An Exploration of Deficiencies Within the Proposer's Environmental Statement on Noise and Vibration

This is a written representation submitted to the Planning Inspectorate as part of the examination of the Hinckley National Rail Freight Interchange (HNRFI) submitted by Tritax Symmetry (Hinckley) Limited. This document contains an exploration of deficiencies within the proposer's Chapter 10 on Noise and Vibration, particularly the [Main Statement, document reference: 6.1.10 \("the report"\)](#).

Figure 1 – Identified Existing Sensitive Receptors

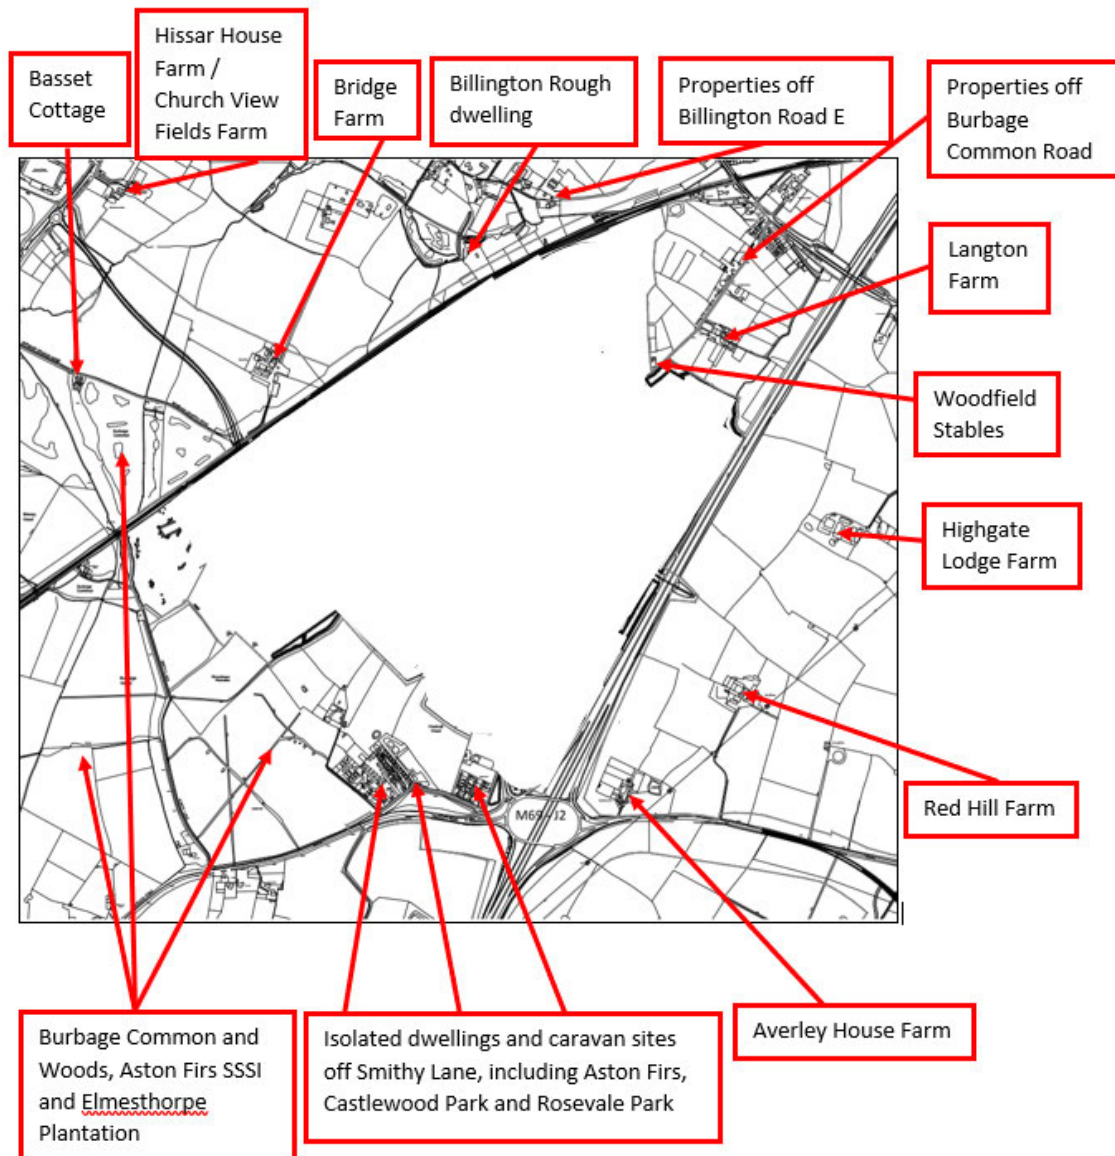
ML4, subsequently referred to as NMP4, is said to be “Representative of Bridge Farm, the single dwelling at Billington Rough, dwellings off Billington Road East”.

Some properties which would later be seen as Noise Sensitive Receptors (NSRs) are not listed as “Identified Existing Sensitive Receptors” in the Noise Survey Method Statement. At the time of the Noise Survey Method Statement, it was not claimed that monitoring location ML4/NMP4 was representative of as many receptors as would be claimed in the report.
